# CITY OF ALBUQUERQUE

August 4, 2023

RE: **Lot 12 Block 4 Volcano Cliffs SAD 228**  
**6411 Canavio Pl. NW**  
**Grading and Drainage Plan**  
**Engineers Stamp Date: 6/23/2022 (D10D003D12)**  
**Pad Certification Date: 8/17/2022**  
**CO Certification Date: 7/28/2023**

ENGINEER'S SEAL 6/23/22 DAVID SOULE P.E. #14522	LOT 12 BLK 4 VOLCANO CLIFFS 6411 CANAVIO PLACE	DRAWN BY RGE
	GRADING AND DRAINAGE PLAN	DATE 6-22-22 6411CANAVIO.DWG
 PO BOX 53924 ALBUQUERQUE, NM 87199 (505) 321-8099	SHEET # C1	JOB #

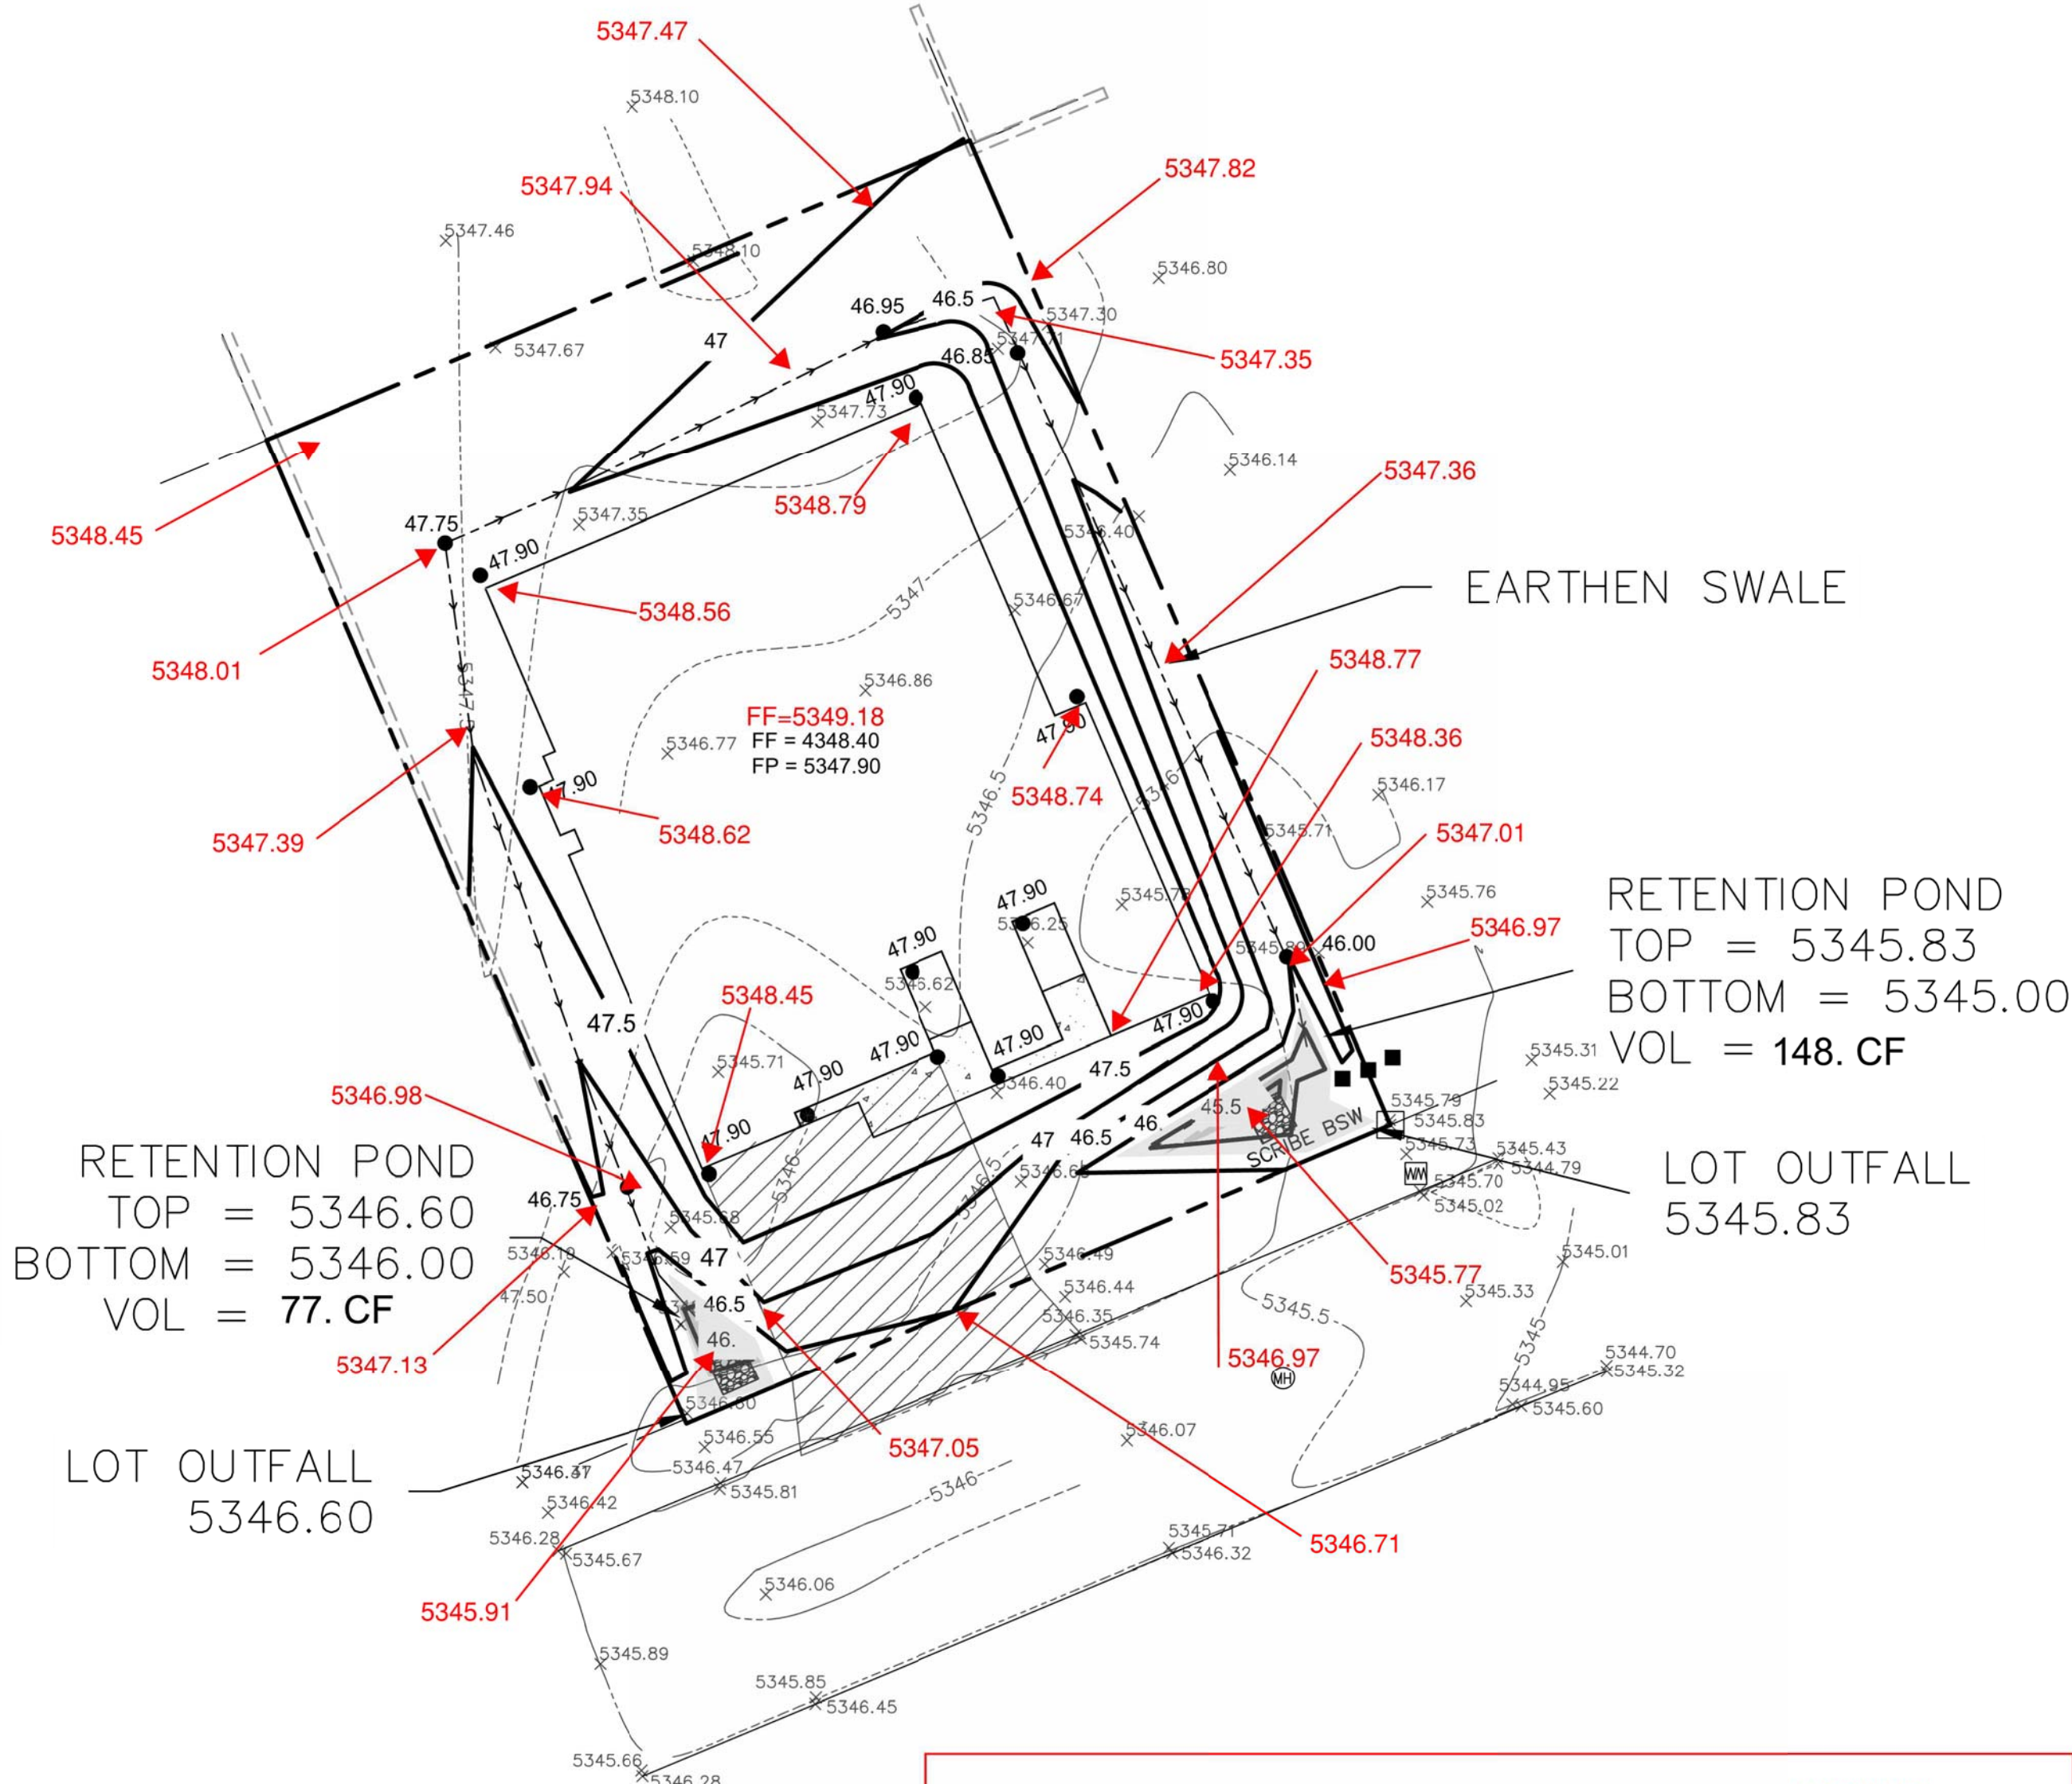
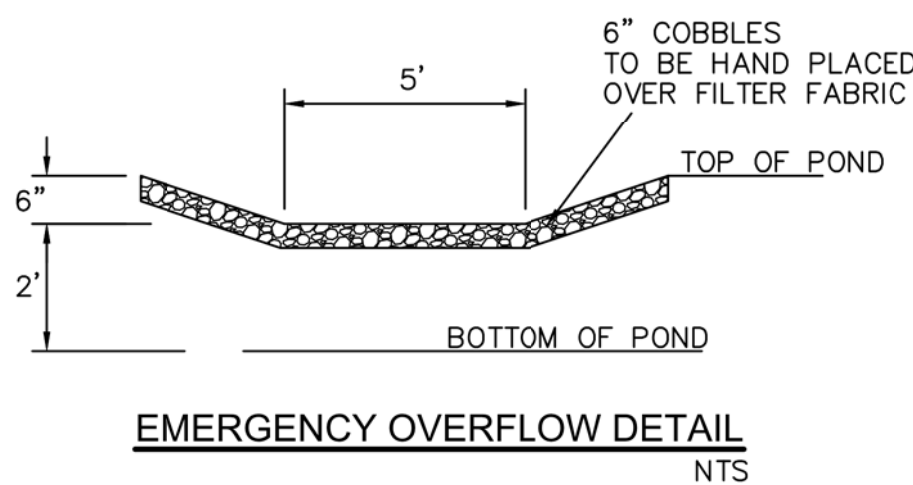
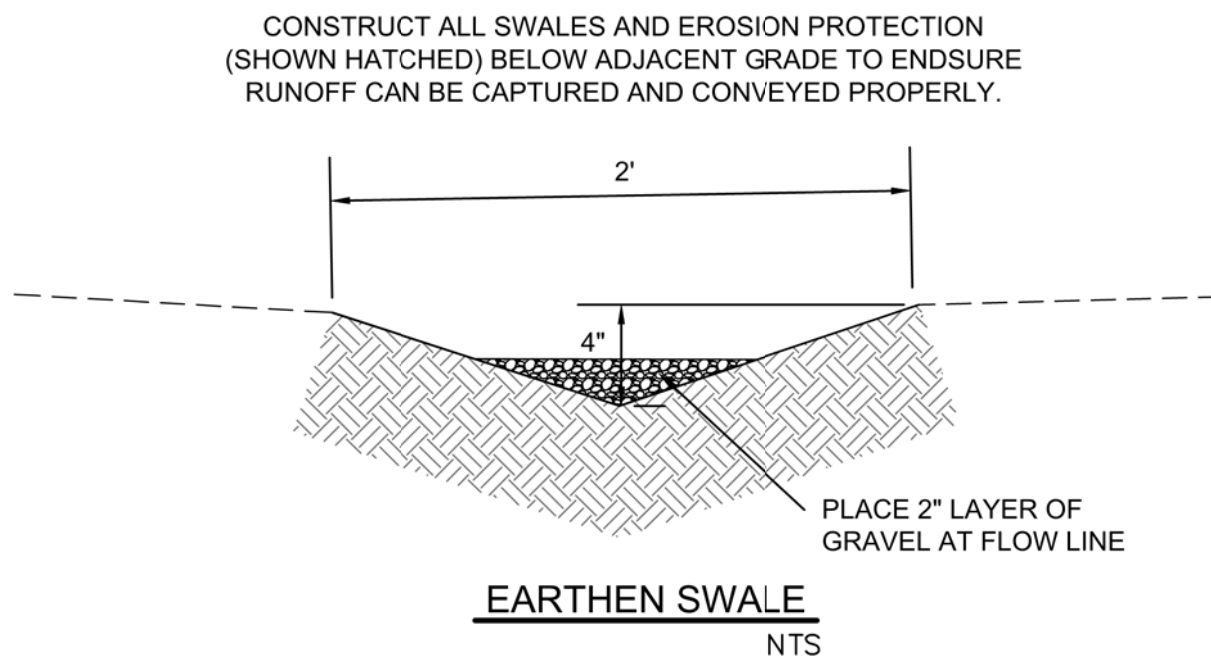
- Ponds must be filled with some type of gravel for erosion control.
- The gravel in place is not acceptable to prevent dirt from entering the public right of way. The flows will carry the sand past the gravel and into the street.
- It appears that flows will be in the neighbor's property, this must be addressed.
